Recommendation Report for Planning Permission for Works or Extension to a Dwelling

REF NO: AW/17/25/HH

LOCATION: 18 Marlborough Court  
Aldwick  
PO21 5QJ

PROPOSAL: Installation of front porch canopy, raise existing garage flat roof to facilitate conversion to habitable use, conversion of loft to habitable use including the installation of side rooflights and alterations to fenestration/openings and external materials.

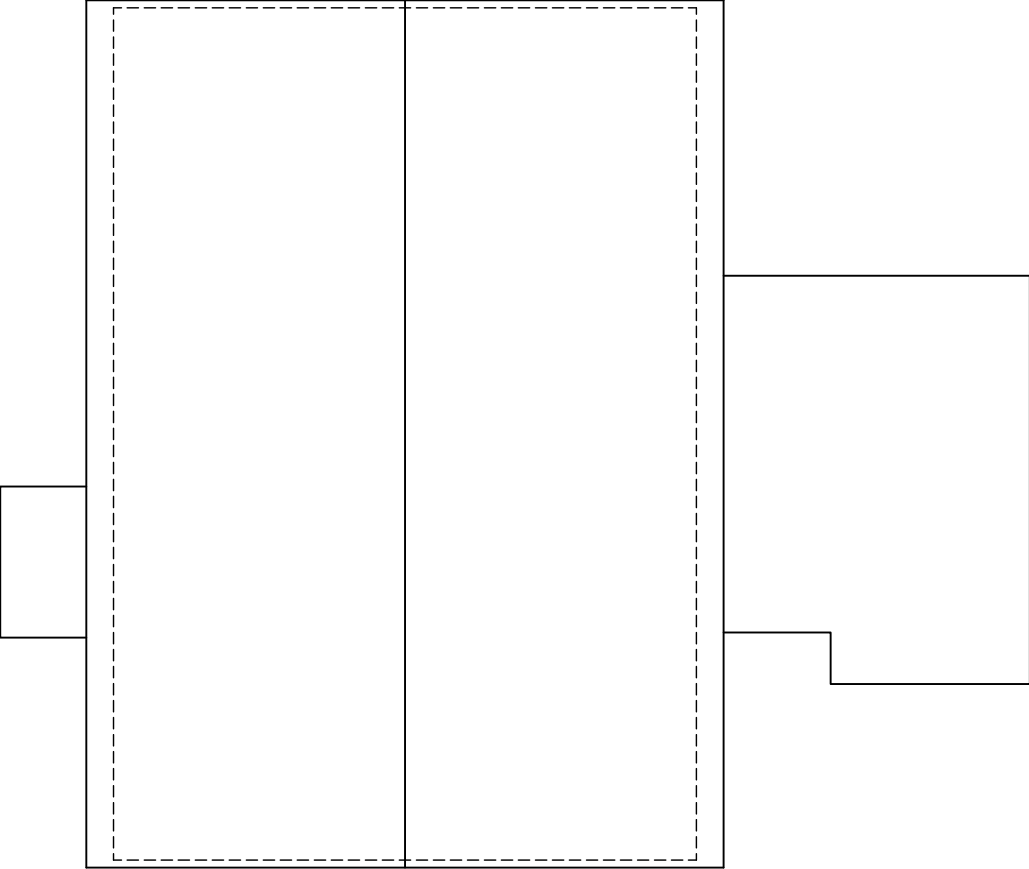
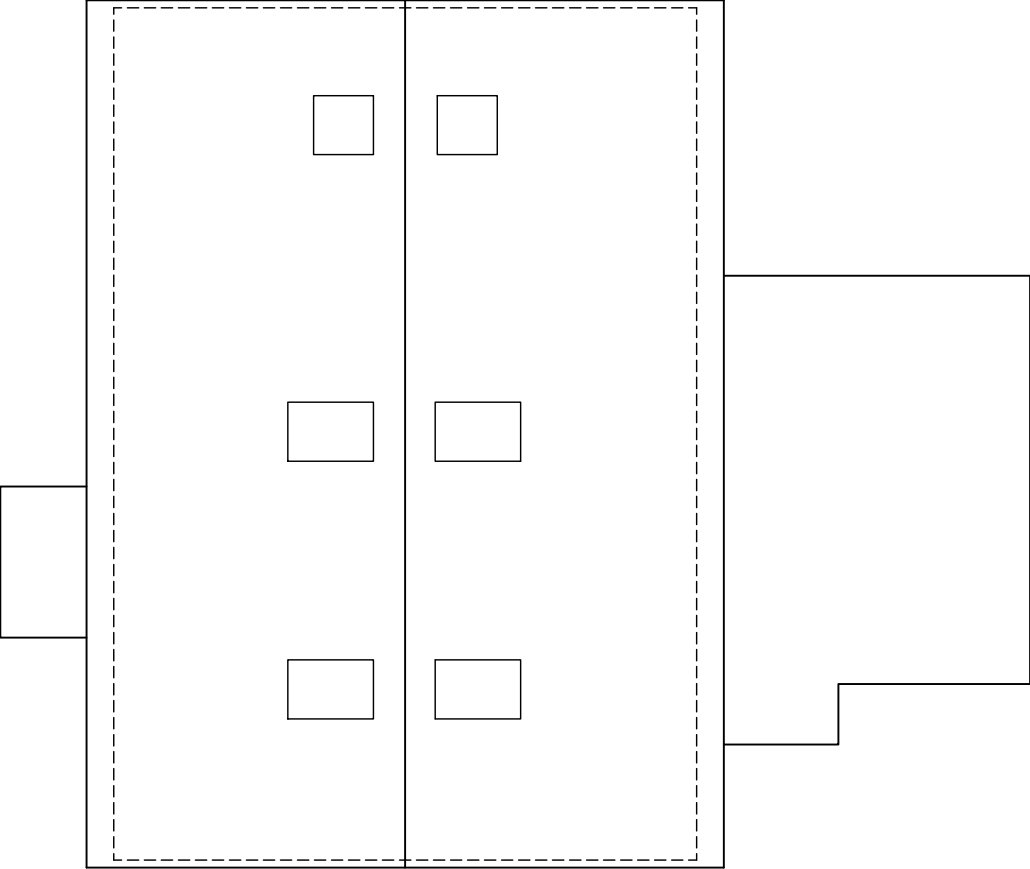
The loft conversion would increase habitable space at first floor level. The works would likely fall under permitted development (with the exception of change in materials) as the proposed loft conversion would not alter the original pitched roof height and character of the dwelling. The proposed roof works would not appear prominent within the street scene. It is noted that the new fibre cement introduces a new cladding element to the front gable feature of the dwelling, however given that there are examples of dwellings within Marlborough Court that have varying elevational treatments, the materials would be acceptable. The loft accommodation would be served by three rooflights on either side (north east and south west) of the roofscape. The proposed rooflights would be proportionate in scale and number and would not result in harm to the character or appearance of the host dwelling.

Rooflights are proposed within the flank roof slopes (east and west) of the host dwelling. The rooflights are present at a height of approx. 1.7m from the finished floor level and given the height, the siting and style of the rooflights, the rooflights would not result in unacceptable overlooking to neighbouring properties and are acceptable.

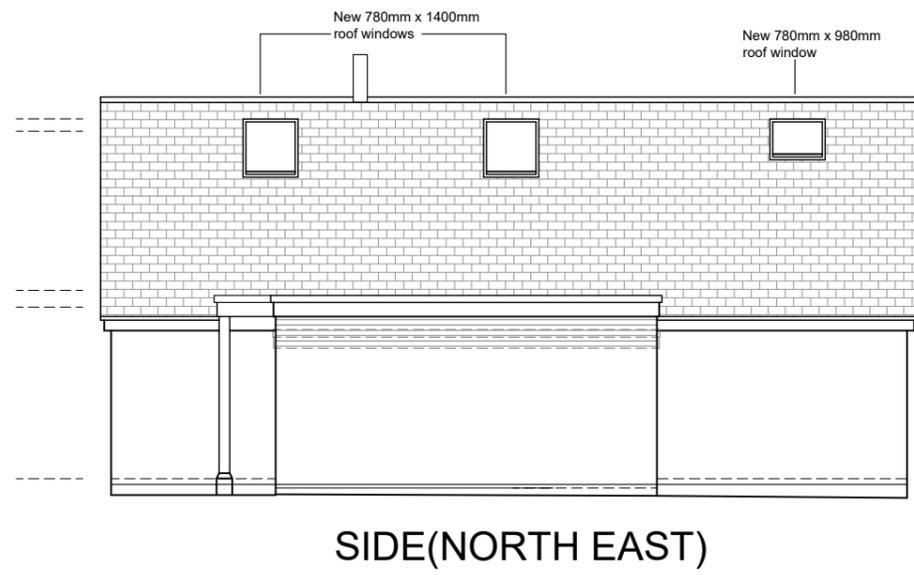
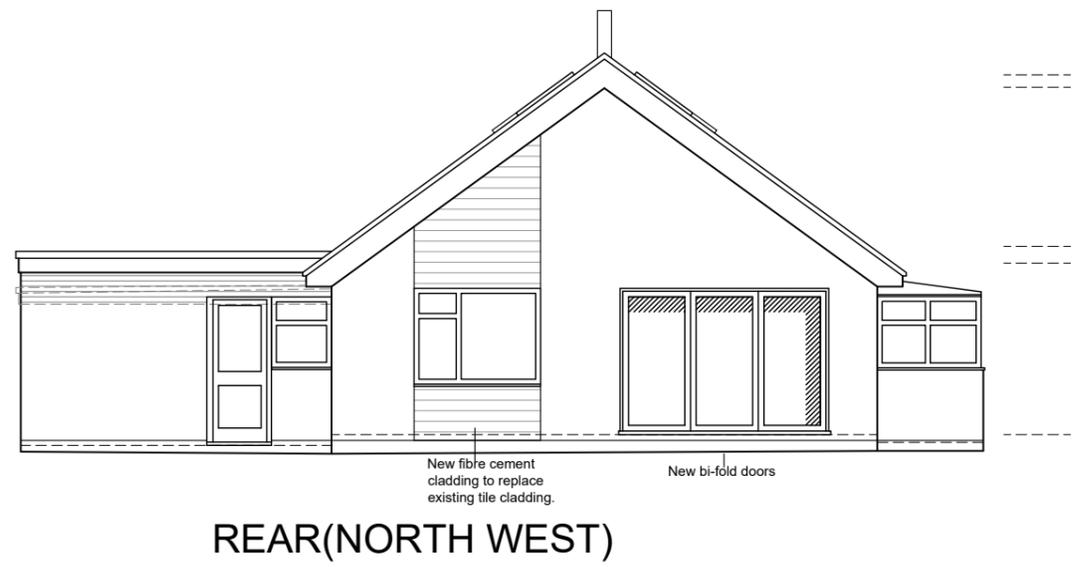
The proposed front porch would measure approx. 2m in width by 1.4m in depth and it would be a minor alteration to the front elevation of the dwelling. Given the scale of works proposed, the proposed front porch would not result in any harm to the character of the dwelling or surrounding area.

It is stated in the Arun Design Guide (ADG) that front extensions should take care not to disrupt the existing composition of the street in terms of rhythm or building line and ensure continuation of existing building design in terms of details and materials. Front extensions should be no deeper than 1.5m. The front porch would comply with this guidance.

The garage conversion would result in external changes including the replacement of the garage door with a window and increase in height of the garage by 0.3m, from 2.5m to 2.8m. Further alterations are proposed to the front south eastern flank elevation of the dwelling, replacing the porch door and window with a different door and window. Internal changes are proposed to the garage to convert the garage to a study, utility and store. The proposed alterations to convert the existing garage would be small in scale, and given the existing variation within the street scene of Marlborough Court in terms of side projections and porches, the proposed garage conversion would not result in any harm to the character or appearance of the host dwelling.

The alterations to the cladding to the walls of the host dwelling would include the replacement of the existing face brickwork and tile hanging with fibre cement cladding and render. The gable ends would also feature new fibre cement cladding. Whilst the proposed materials would alter the appearance of the host dwelling, the street scene is varied in terms of elevational treatments and the replacement cladding would not result in any harm in this regard.

The proposed alterations to the garage would include an increase in the height of the flat roof over the garage by 0.3m, from 2.5m to 2.8m. The proposed increase in height would be small in scale, and given that the neighbour to the north east is set in from the shared boundary, the proposed increase in height would not result in overbearing or overshadowing effects to this neighbour.

Fenestrations proposed to the garage to the front and rear elevations would have an outlook of the front and rear amenity of the property and are acceptable. They are ground floor fenestration changes and are minor, providing views already achievable from the existing fenestration.
